Ribble Valley Borough Council
Housing & Development Control

Application no: **3/2023/0126**

Address: **Bent House Longtons Lane Tosside BD23 4SU**

Proposal: **Proposed change of use of part of site to eco-retreat, wellness re-wilding centre.**

Drawing Title
PROPOSED SITE PLAN

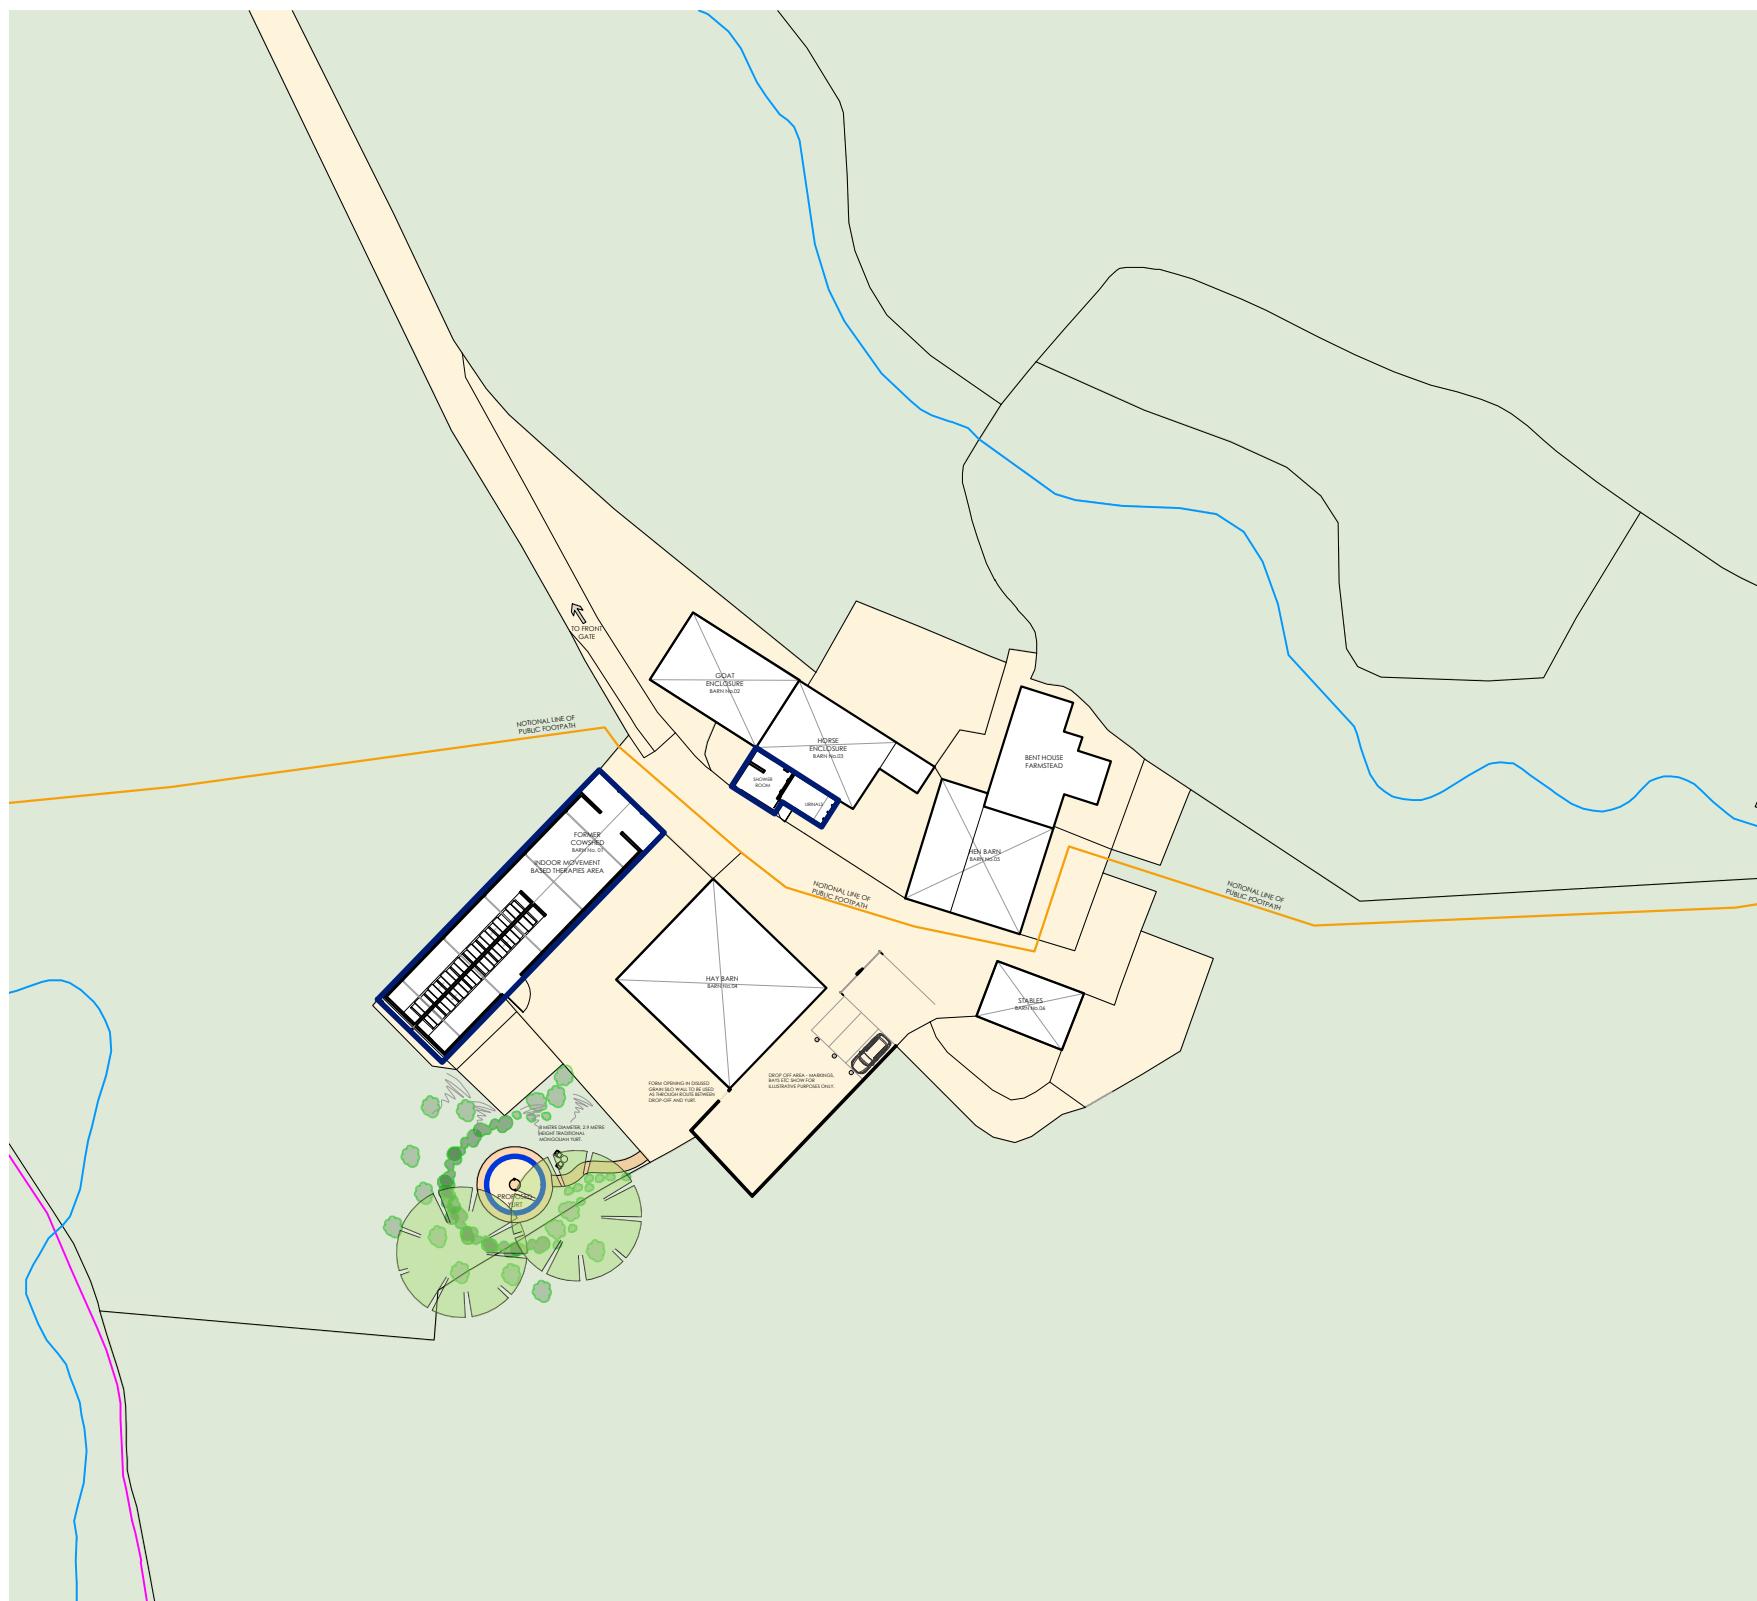
The LHA have reviewed SPA drawing number 6681-S02B titled "Proposed Site Plan" and are aware that 3 car parking spaces will be provided. However, to ensure that adequate parking is provided at the site, the LHA require further details regarding the maximum number of staff members on site at any one time and whether one vehicle will be used as the designated and drop off service for customers. These details can be submitted in the requested Operation Statement.
